Application for a non-material amendment following a grant of planning permission. Town and Country Planning Act 1990

8. Non-Material Amendment(s) Sought

PROJECT:  
NEW REAR EXTENSION AND FREESTANDING GARAGE @ "BRANSTONE", ULGHAM, NORTHUMBERLAND.  
CLIENT:  
MR M. LEE  
DRAWING TITLE:  
REVISED ELEVATIONS

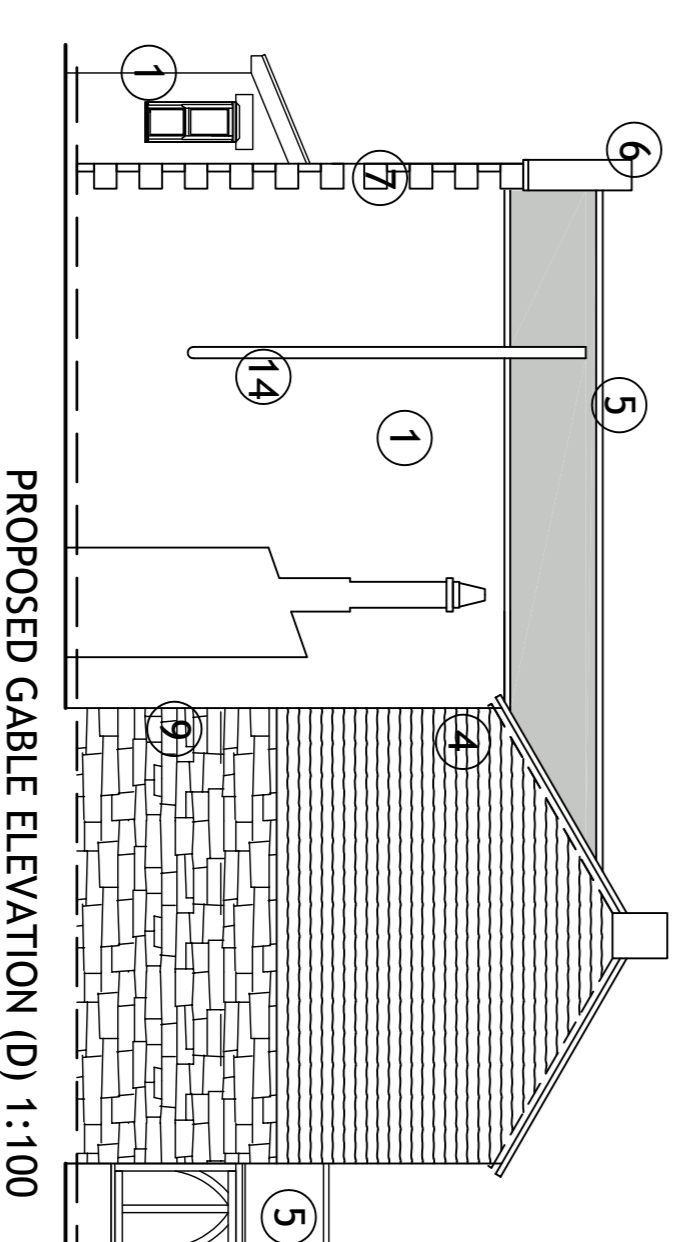
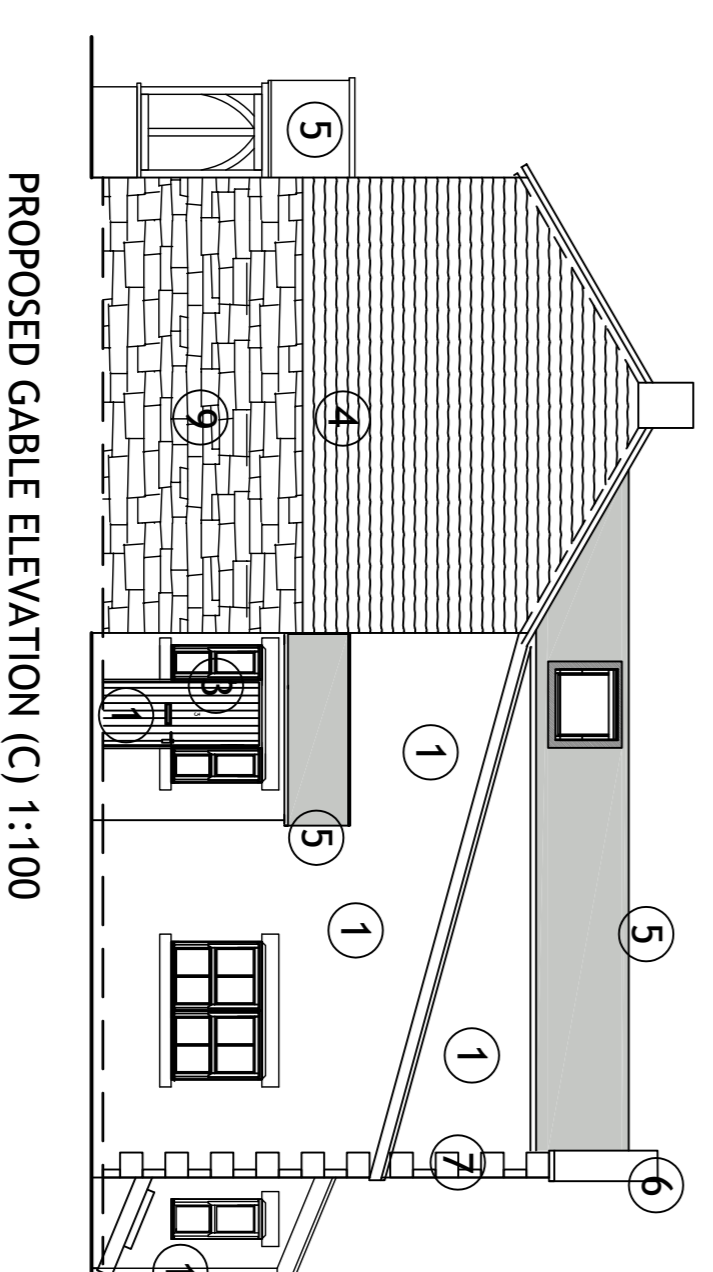
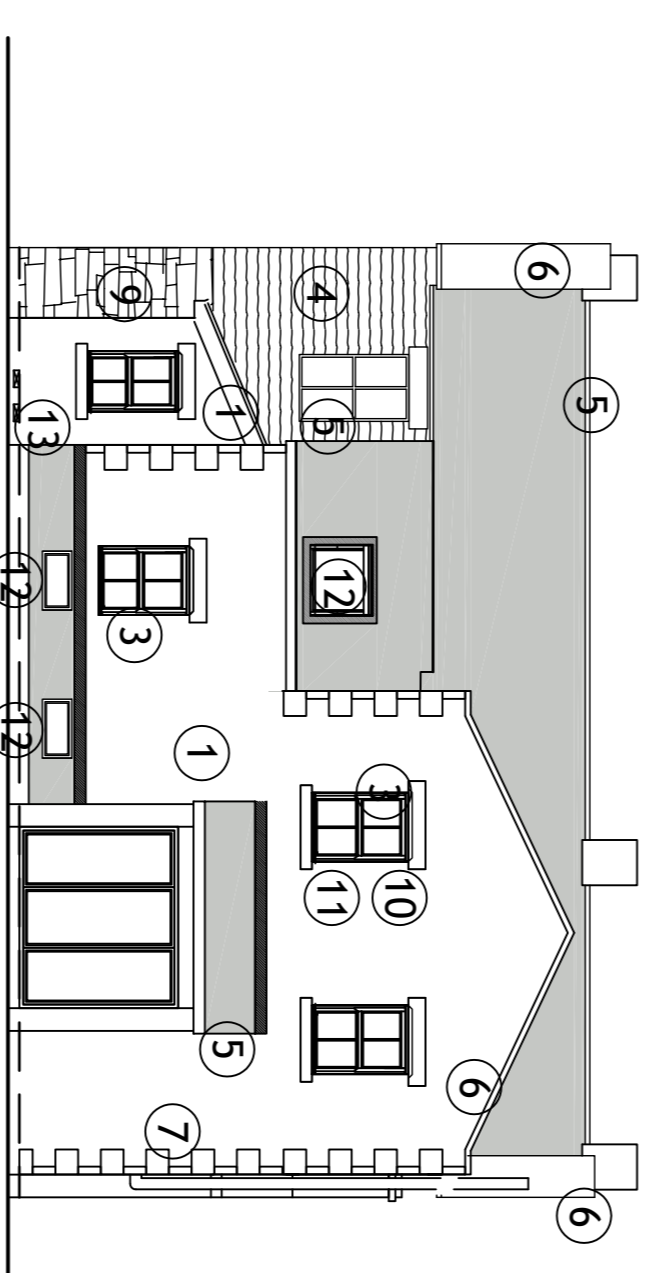
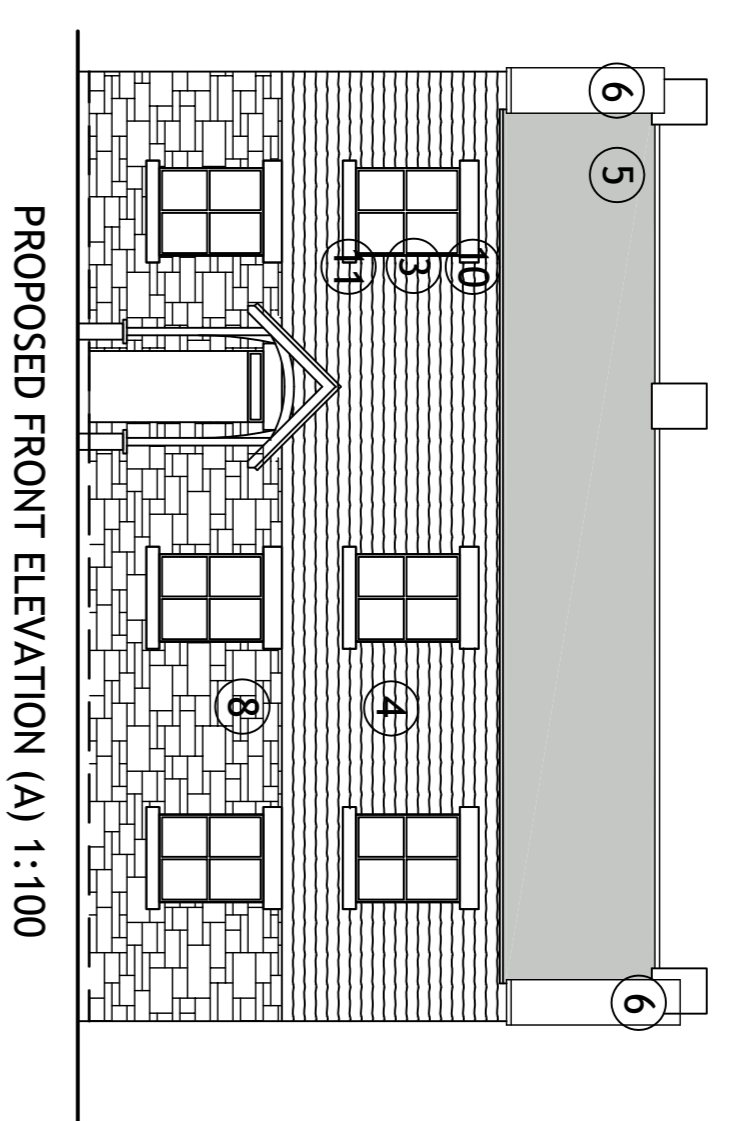
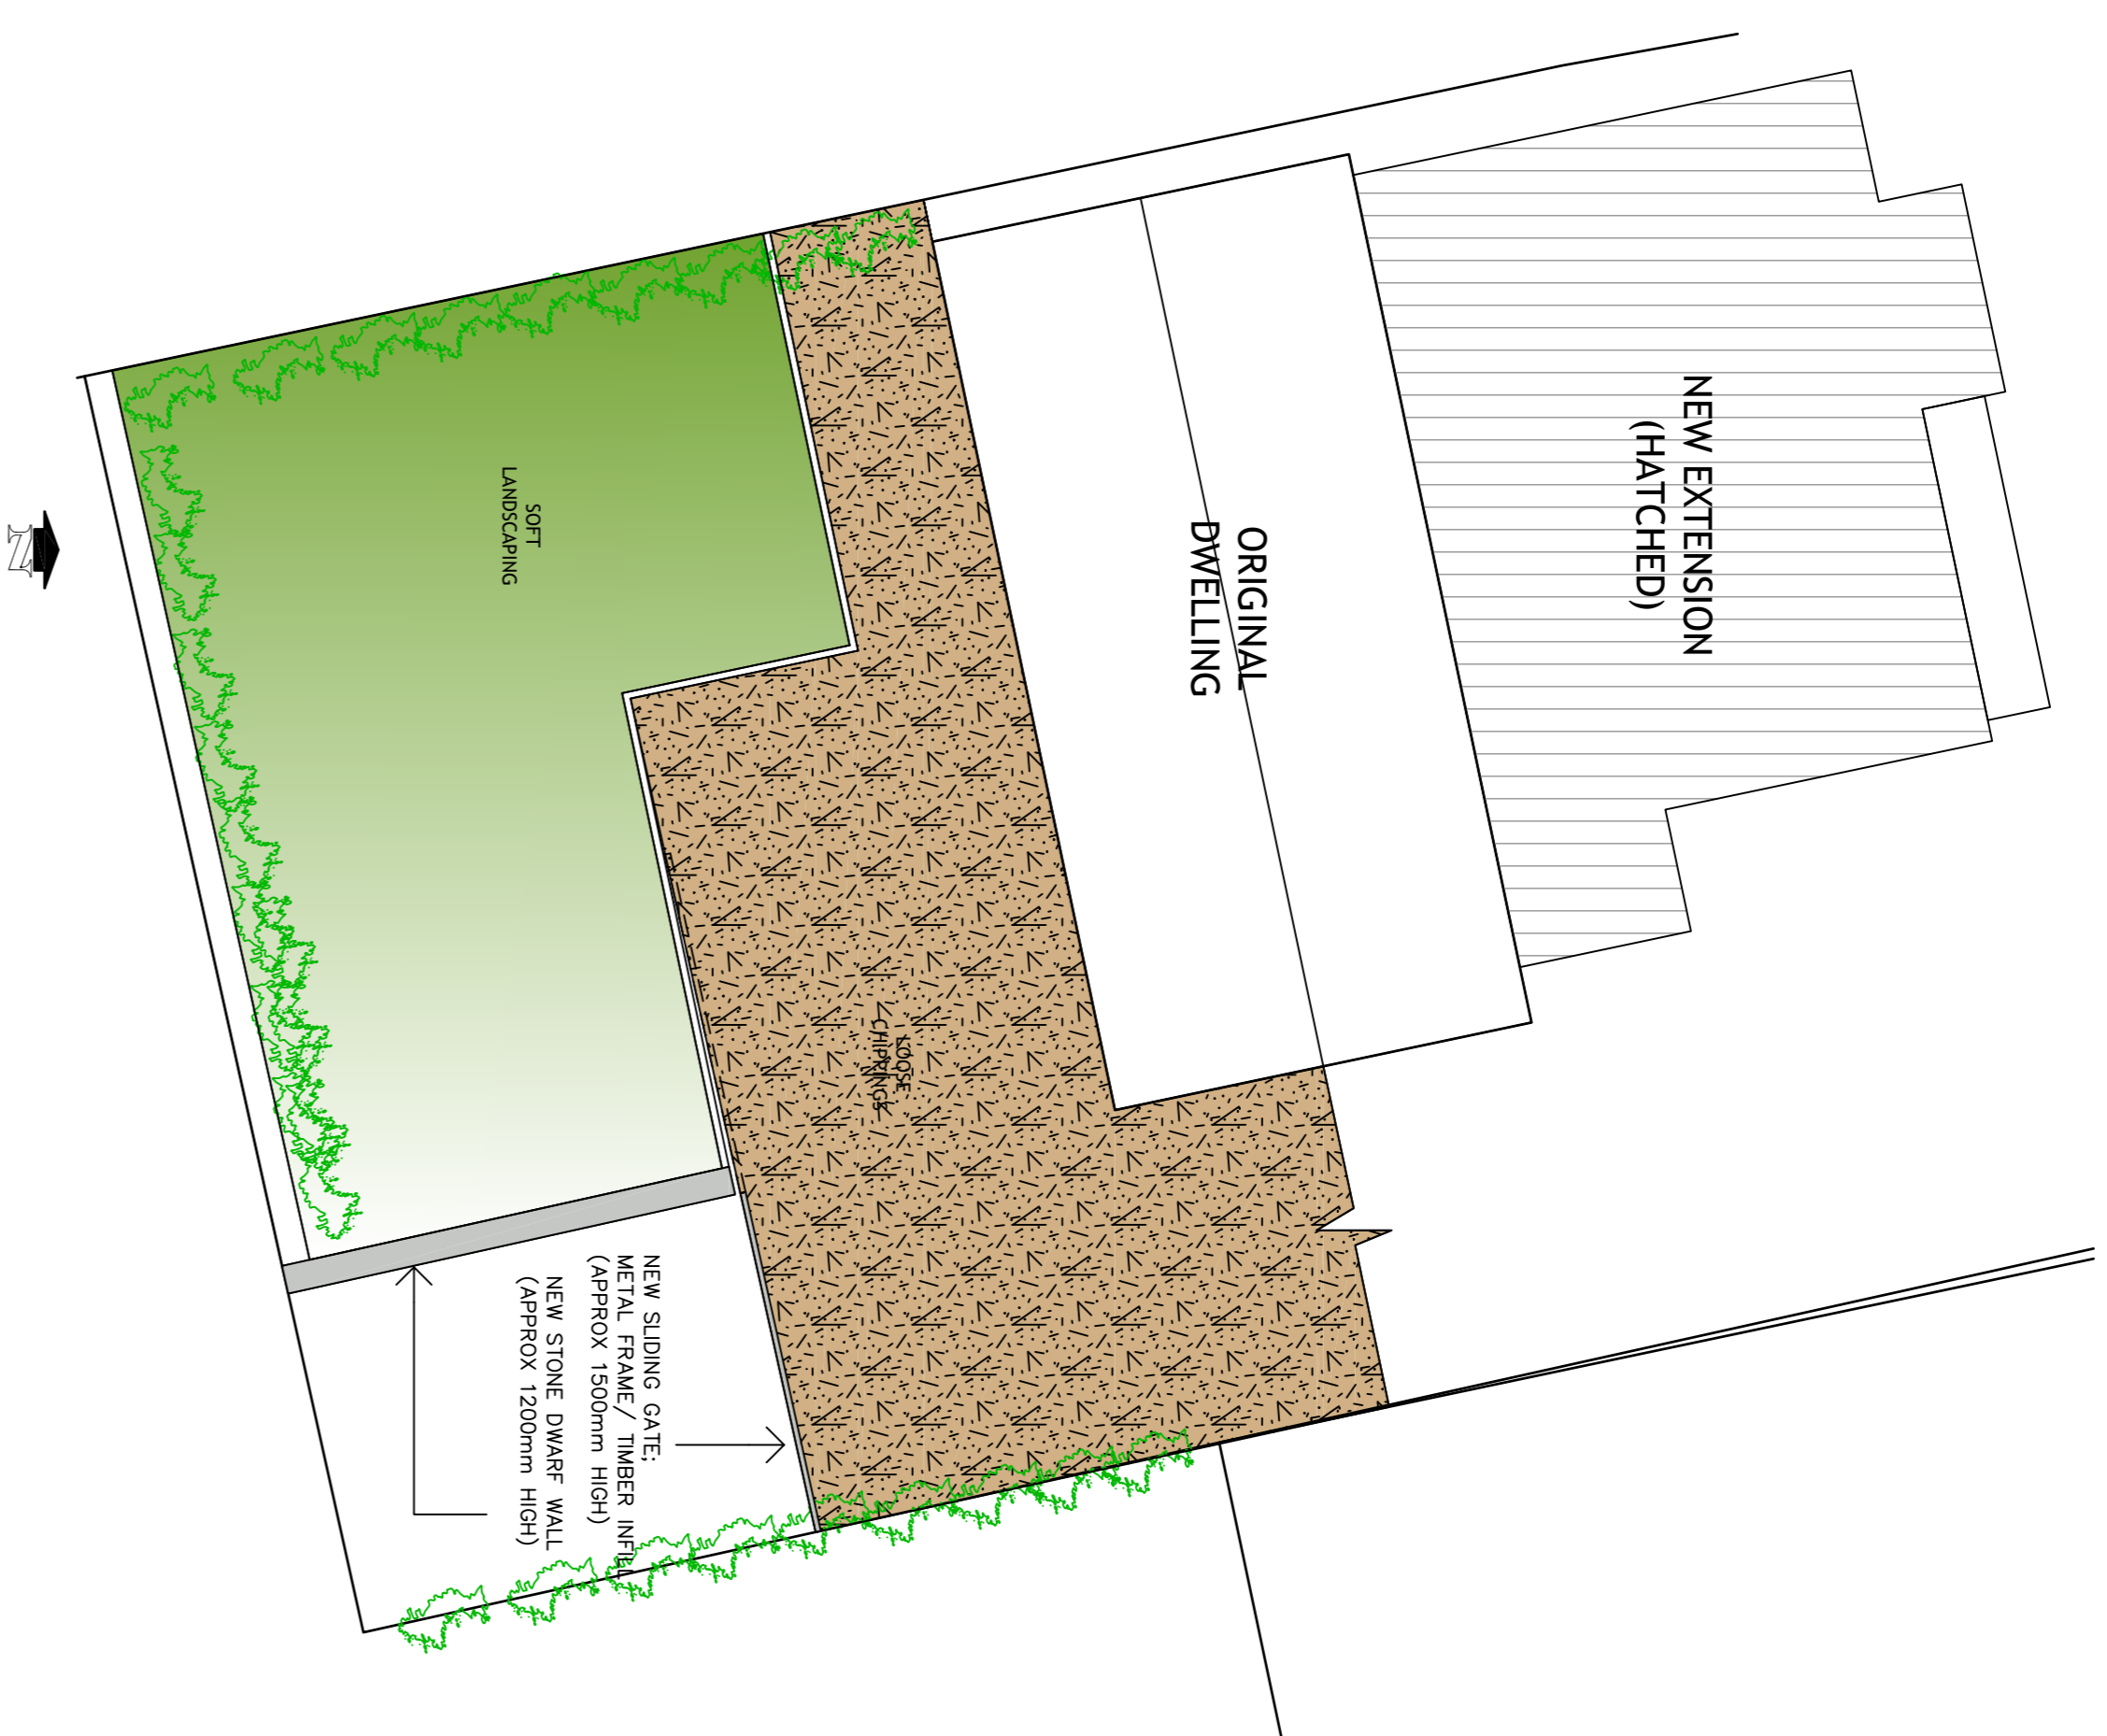
- Alteration of guttering design
- Install of timber cladding in lieu of 'rough cast' finish to existing 'upper' part of house.

- Guttering for accessibility (not seeing access from neighbouring property)
- Cladding for aesthetics and to remove feeling rough cast.
